WELWYN HATFIELD COUNCIL
PLANNING CONTROL COMMITTEE – 5 JUNE 2008
REPORT OF THE CHIEF PLANNING AND ENVIRONMENTAL HEALTH OFFICER

S6/2008/0035/FP & S6/2008/0045/LB

ERECTION OF REPLACEMENT RESIDENTIAL ANNEXE ATTACHED TO LISTED WALL, REPLACEMENT OF EXISTING FLAT ROOF GARAGE WITH PITCHED ROOF. AMENDMENTS TO S6/2005/1561/FP & S6/2005/1562/LB

THE VINES, HIGH ROAD, ESSENDON, HATFIELD, AL9 6HS

Drawing Title
Proposed
Elevations

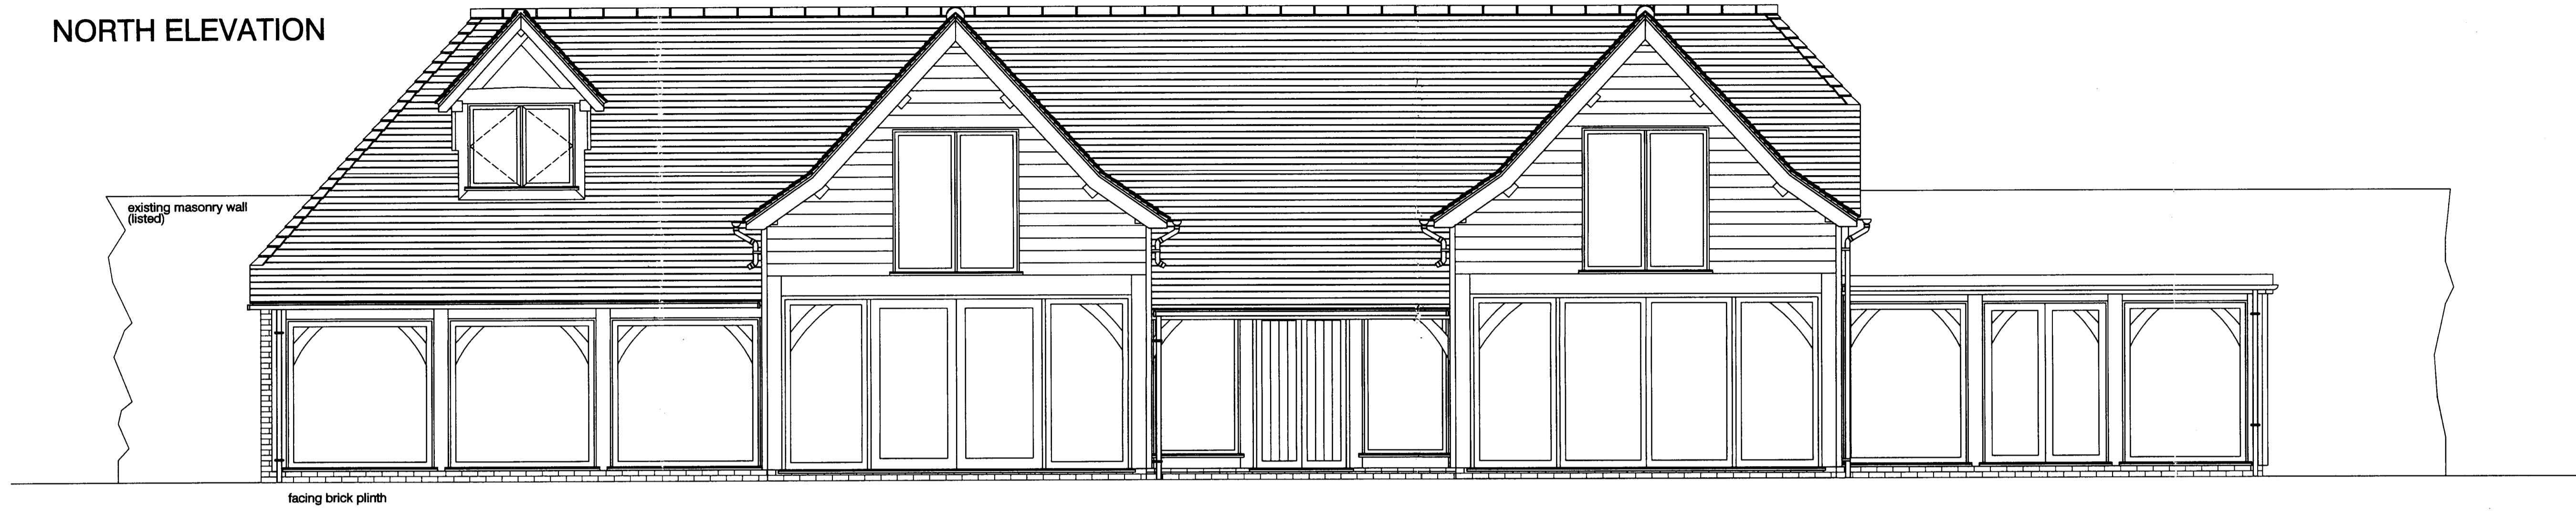
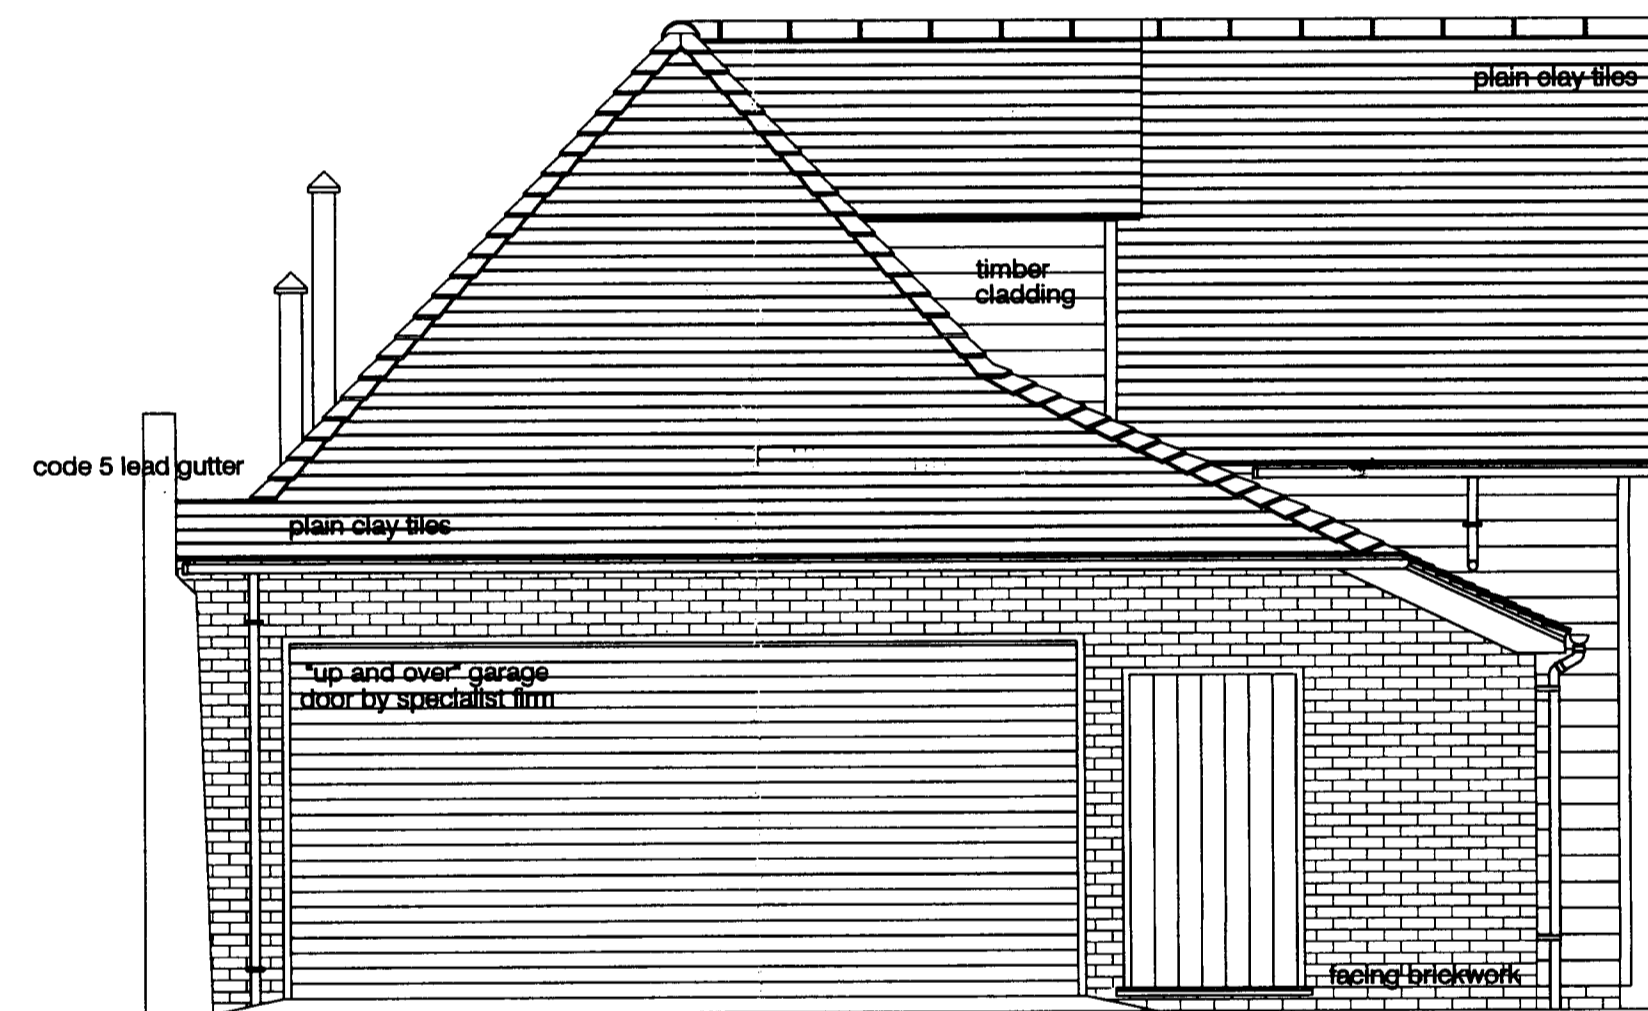
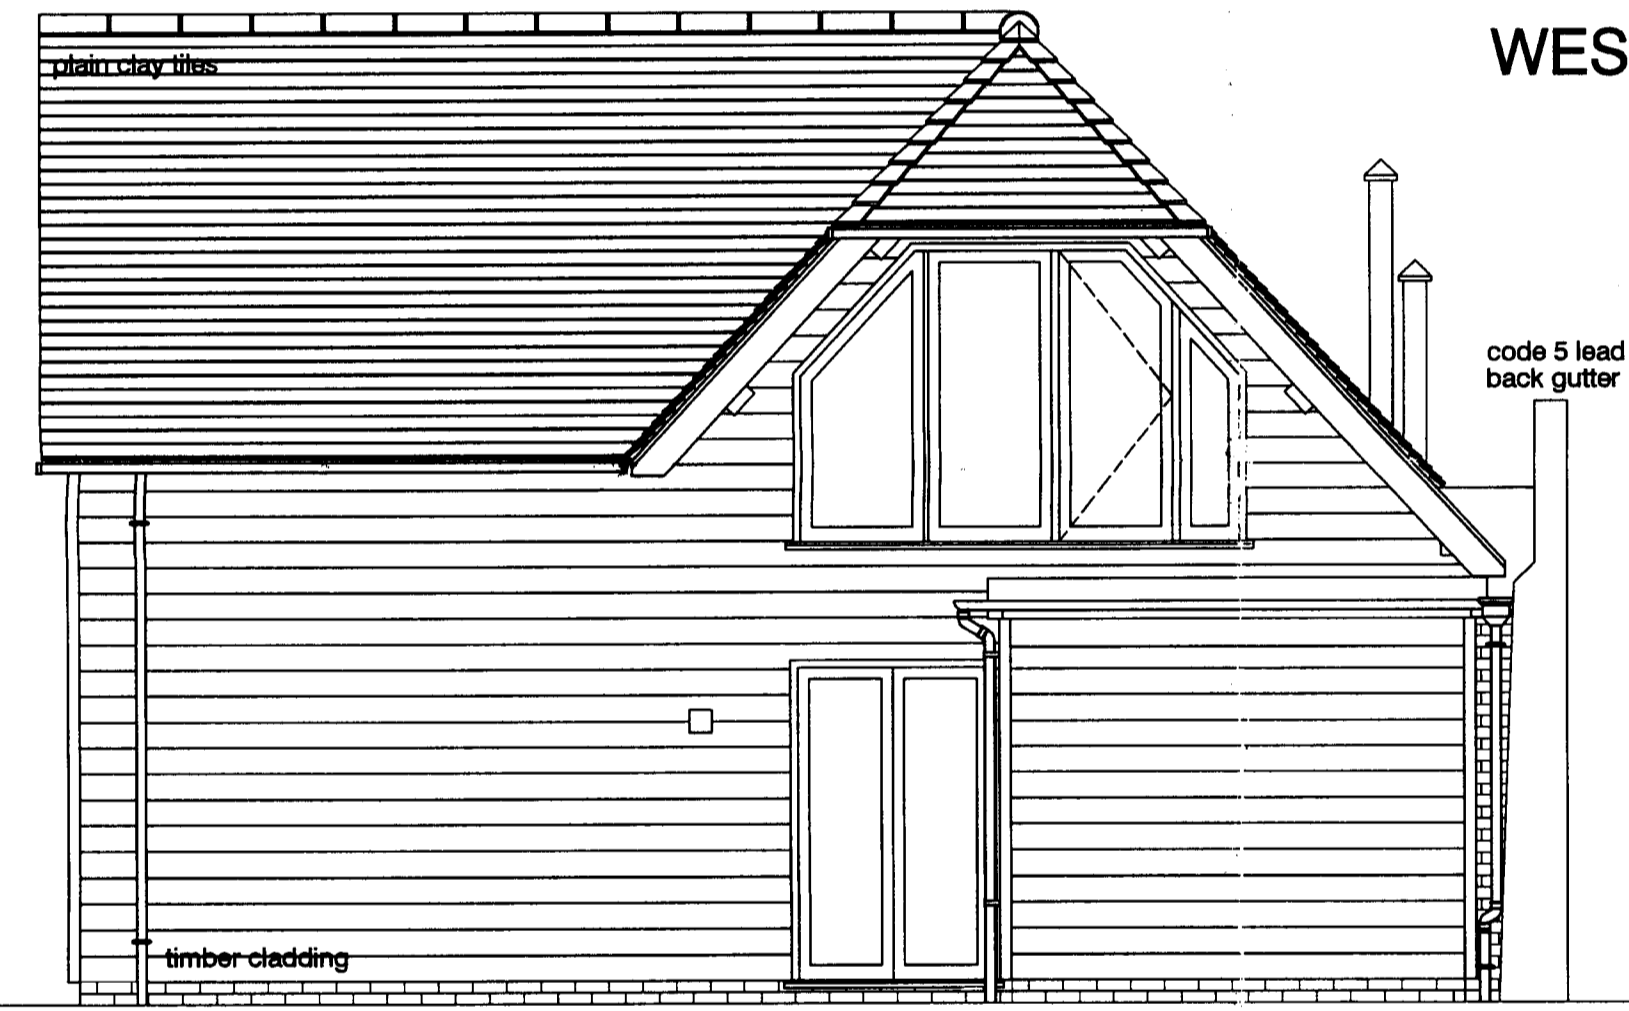
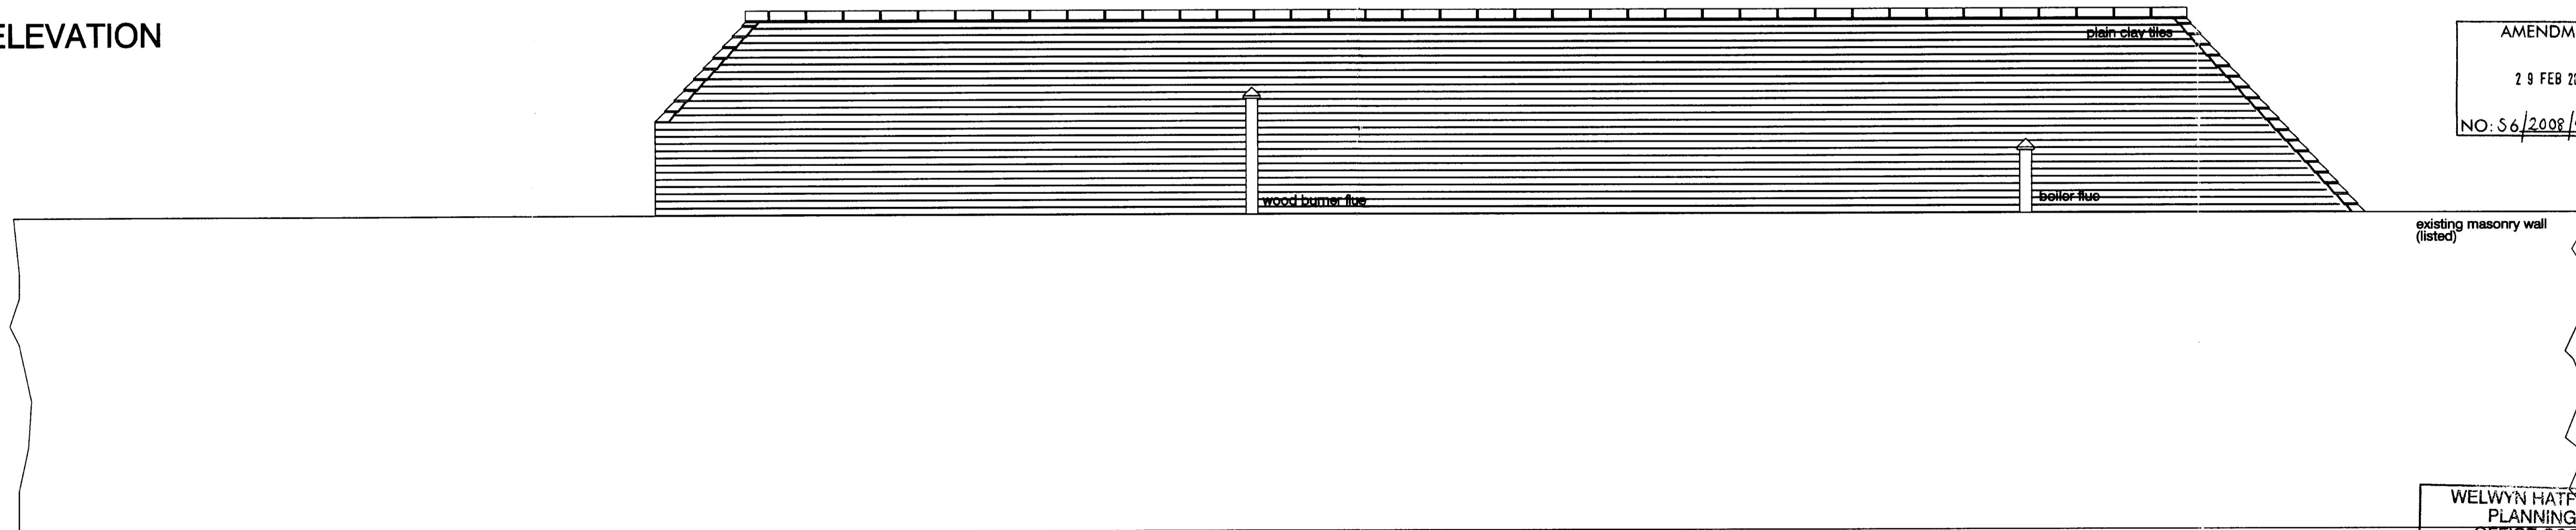
In design terms the main elevation is absurdly elongated and the clumsy extension to the roof, necessary to cover the extra width, is of notably poor design, particularly the eastern elevation now it has lost the earlier parapet device.

The dormer is much larger and is now clearly visible from the side and rear. The application should be refused due to size, bulk massing and design and the overlooking of the neighbouring garden.

- 9.15 Concerns have been raised about the larger first floor window in the western end of the application building in terms of overlooking. However, it is considered that any views to the neighbouring property would be from an oblique angle and so would be very limited. It would therefore be unreasonable to withhold planning permission in regards to overlooking as the development would still maintain an acceptable degree of privacy to the adjoining neighbour.

Drawing Title
Proposed
Ground & First Floor Plans

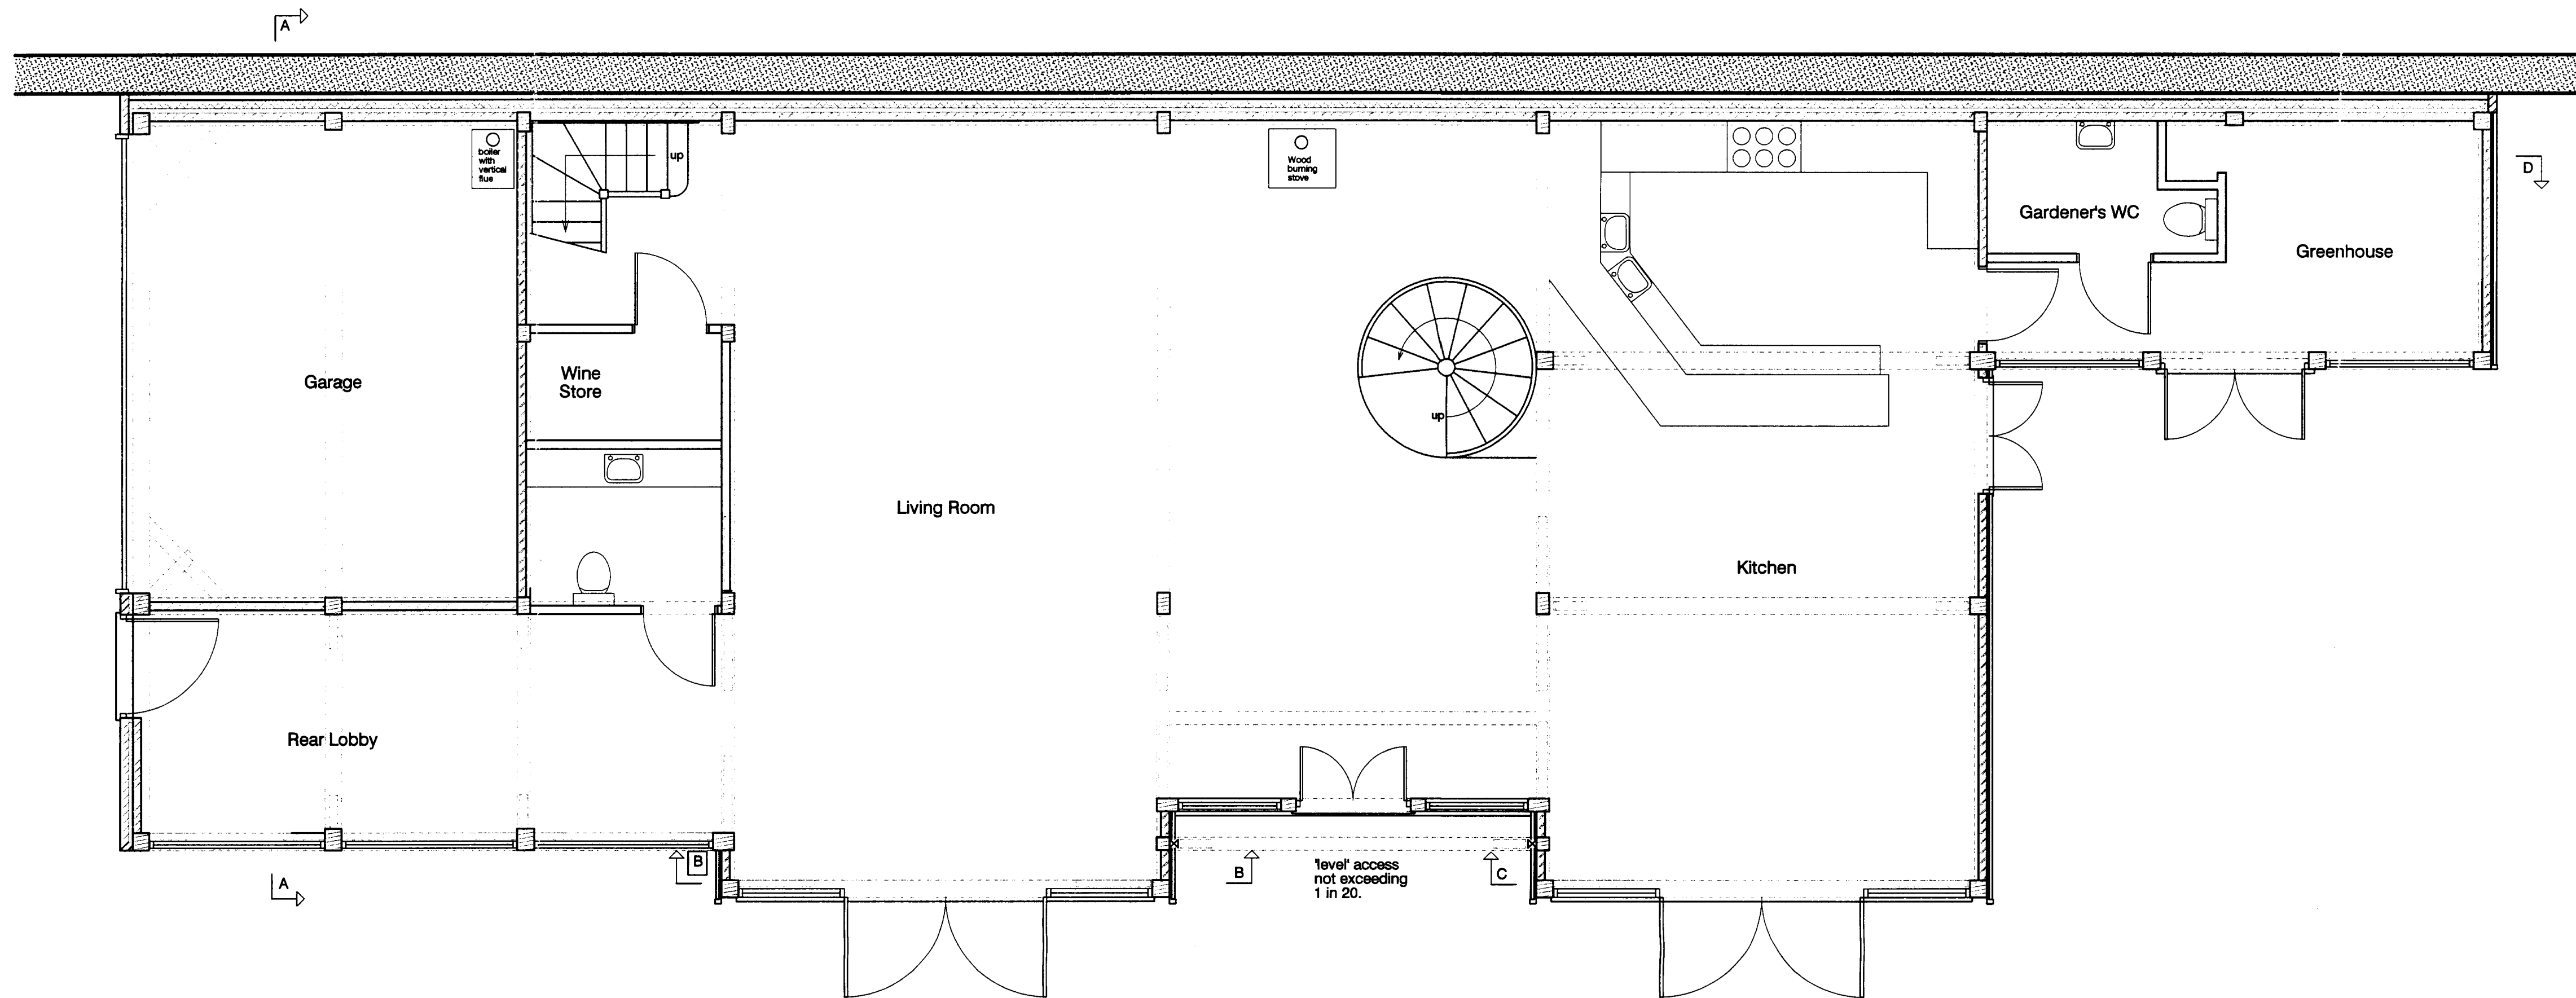
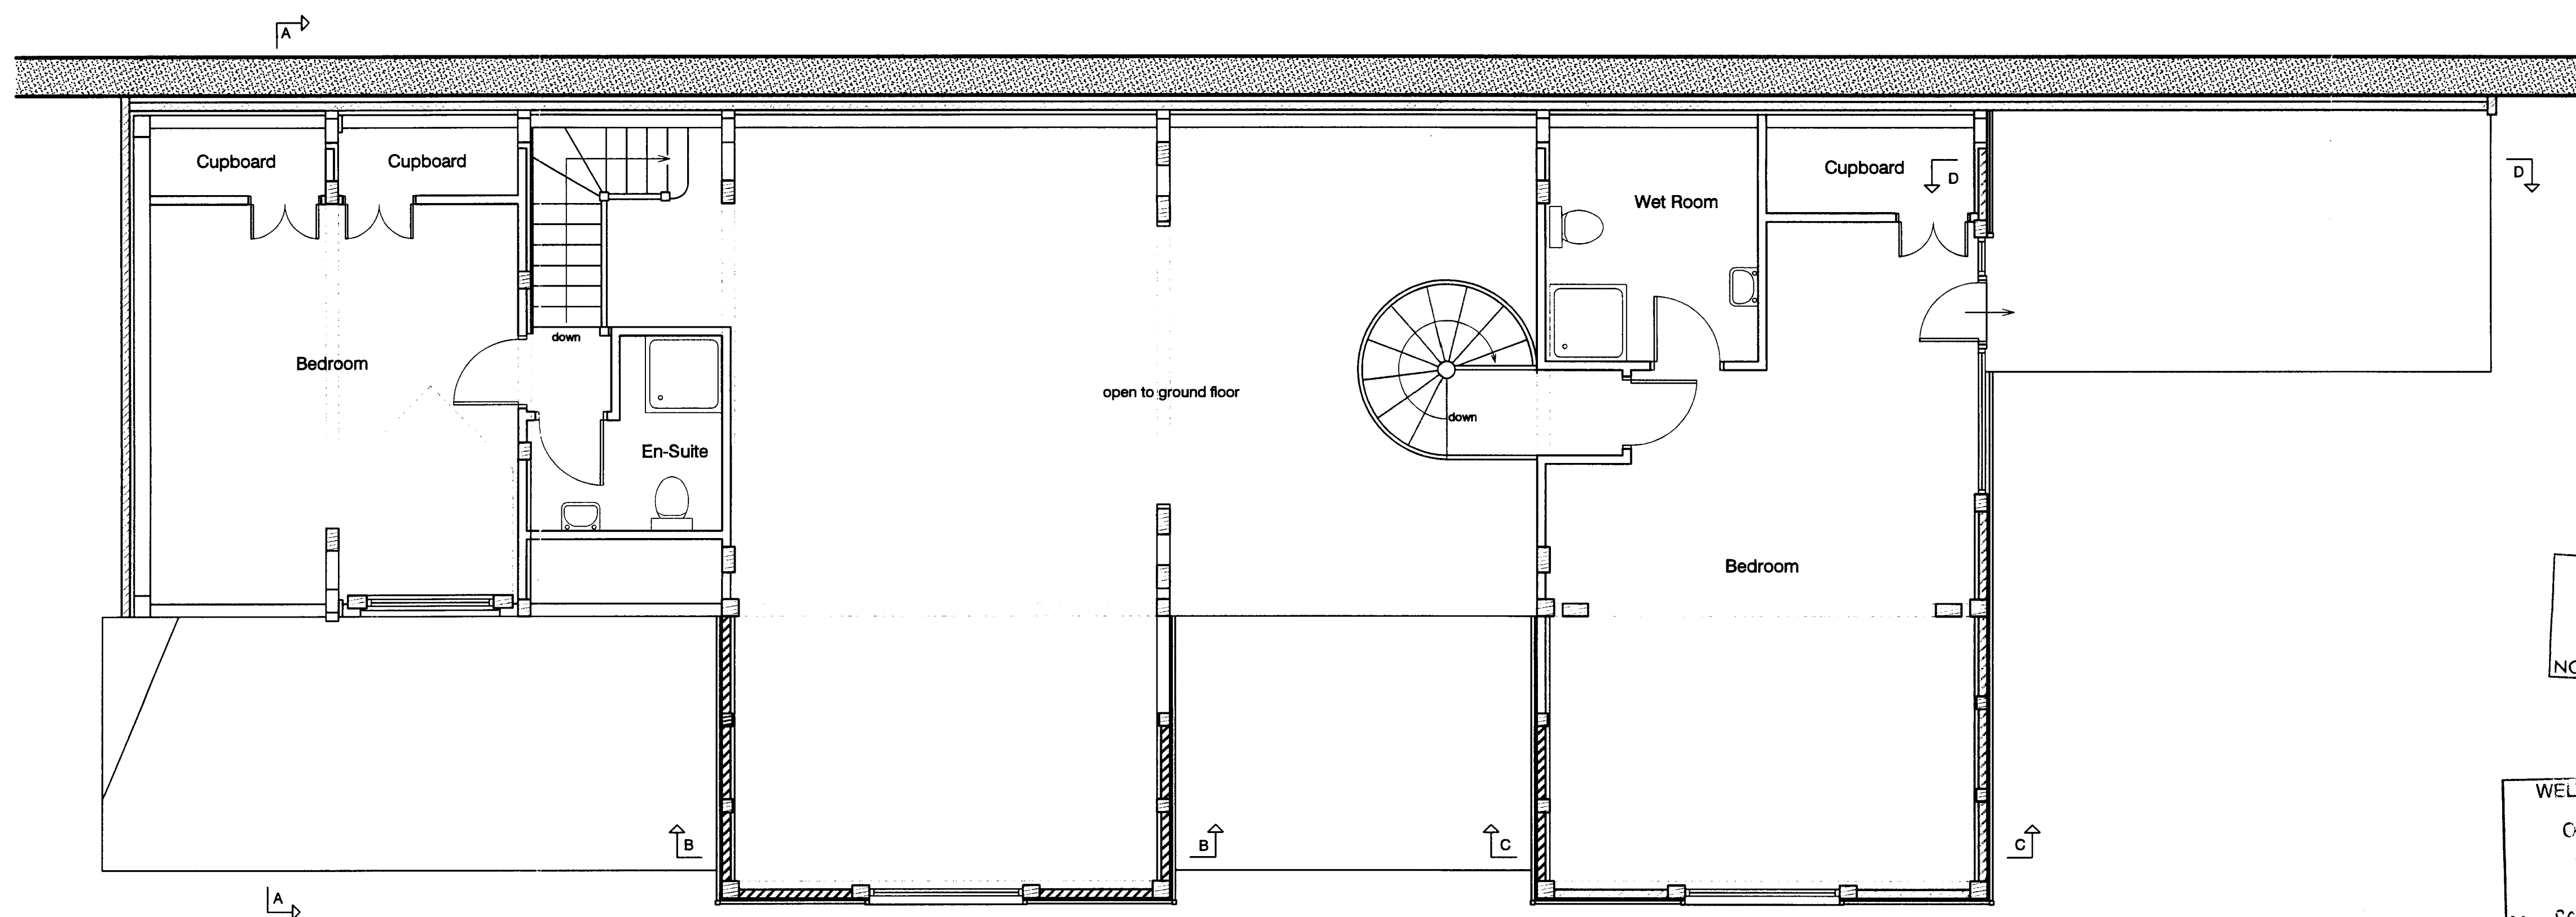
- 9.14 There is also a requirement to consider the potential for overlooking to adjoining neighbours under this policy and guidance. Concerns have been raised by an adjoining neighbour about the potential for the loss of privacy from the flat roofed area over the greenhouse. This proposal has now been removed from the proposed scheme as no external staircase is shown on the design drawings or balustrade. Although no permitted development rights exist for this building, it would be reasonable to ensure that the functional use of this area does remain as a flat roof, as a roof terrace in this location would result in an unacceptable loss of privacy to the adjoining resident. A planning condition restricting the use of this area to solely a flat roof and not as a terrace, balcony or sitting area is suggested for any permission granted.

3. The flat roofed area over the ground floor area which is annotated as 'Greenhouse' and 'Gardeners WC' (on approved drawing 528/02A Received and dated 29/02/08) of the development hereby permitted shall not be used as a balcony, terrace or sitting out area.
